**East Yorkshire Solar Farm
EN010143**

**Applicant's Additional Responses to heritage matters raised by
Written Representations [REP1-119] and [REP1-103] Submitted
at Deadline 1**

Document Reference: EN010143/APP/8.34

East Yorkshire Solar Farm
 Viewpoint 5: Sandwood House, Spaldington Road
 Figure 10-42 (a)

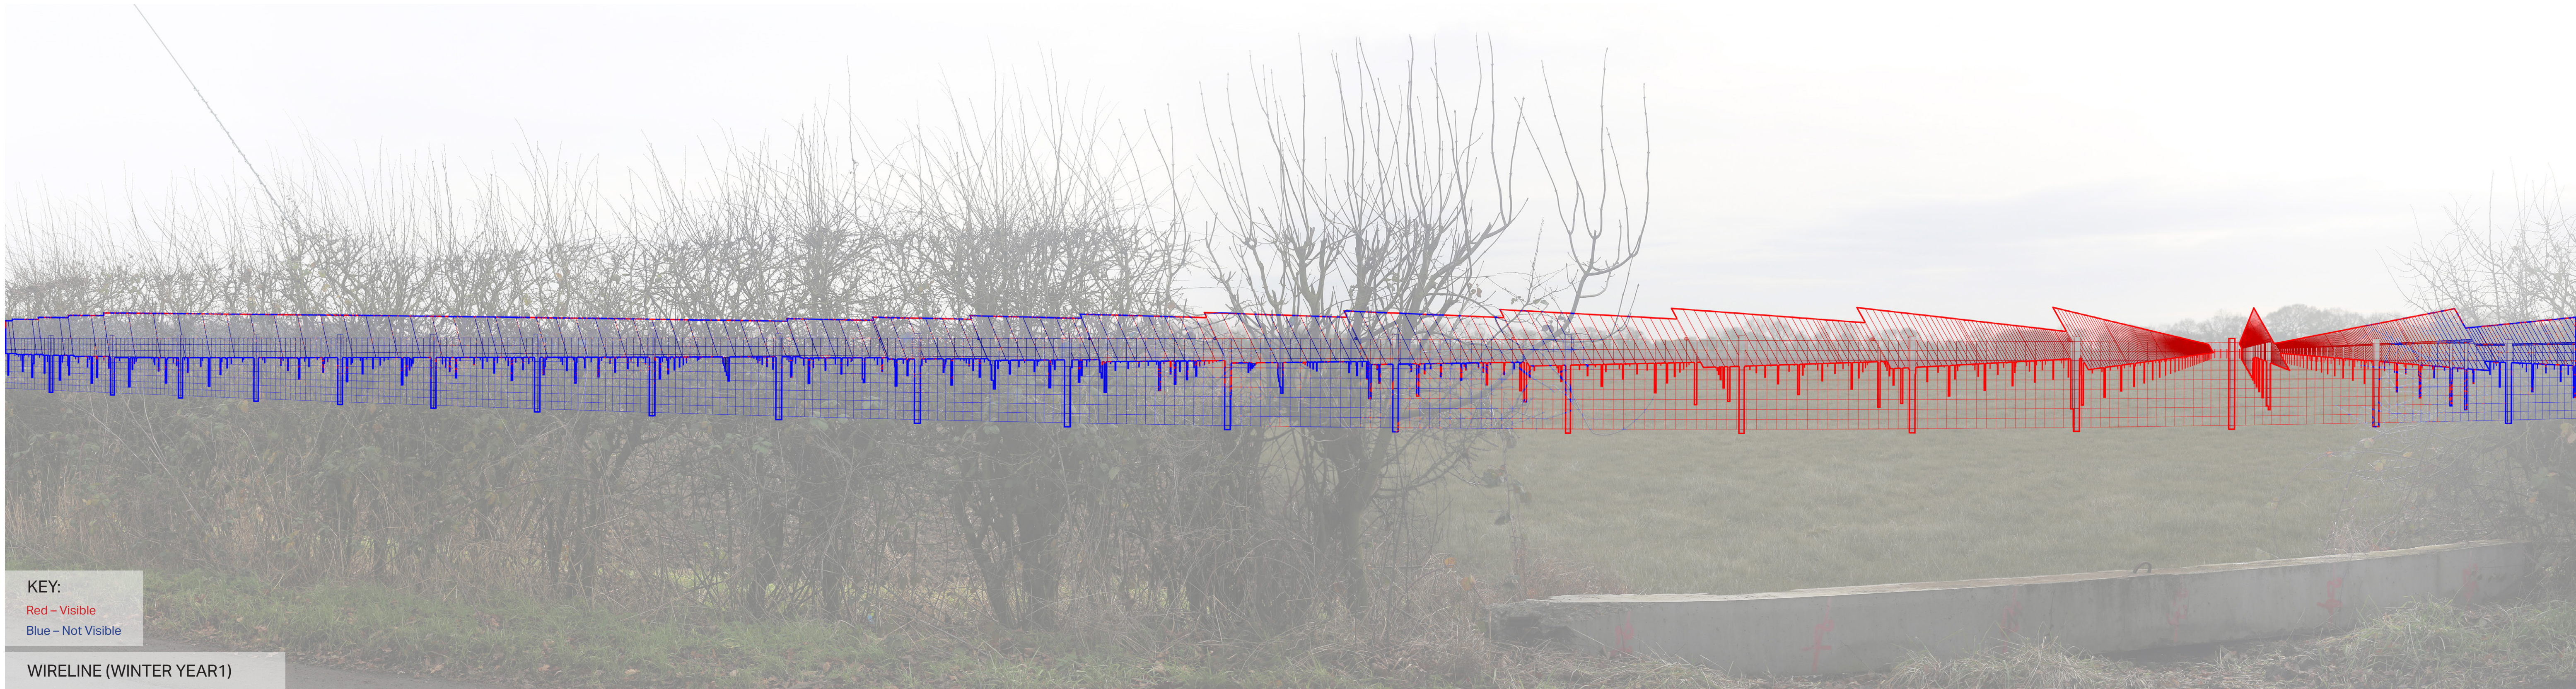
The nearby Sandwood House is also of likely eighteenth century date (it is certainly shown on the 1855 Ordnance Survey map) and appears to also be an historic farmstead.

It is not included in the Humber HER. But again this has not been identified as a NDHA and the impact of the proposed solar farm – it will be sandwiched north and south between two blocks of solar panels (2e and 2f) – on its significance will be even more severe.

Sandwood House is characteristic of an early to mid-19th century rural house. A house is illustrated on the tithe and first edition Ordnance Survey maps for the area, and comparison with modern aerial imagery at the early stage of the DBA process noted levels of change to two offshot structures on its east and west gable ends, but no noticeable change to the principal building.

The principal building, which faces south, looks out onto a small orchard garden which provides its aesthetic and domestic setting and contributes to the house's historical interest and heritage value. Another garden and pond occupy the field to the east of the house, and also contribute to its aesthetic and domestic setting.

Large, modern, agricultural buildings are immediately behind the house, to the north, occupying an area that has housed agricultural buildings since at least the publication of the first edition Ordnance Survey map in 1855. The industrial buildings are modern and do not contribute to the heritage interest of Sandwood House.

The assessment carried out at the early stage of the DBA process concluded there would be no change to Sandwood House as a result of the Scheme, including no change to its domestic and aesthetic setting and, as such, no potential for impact or significant effects to its heritage value. Sandwood House was therefore scoped out from the assessment.
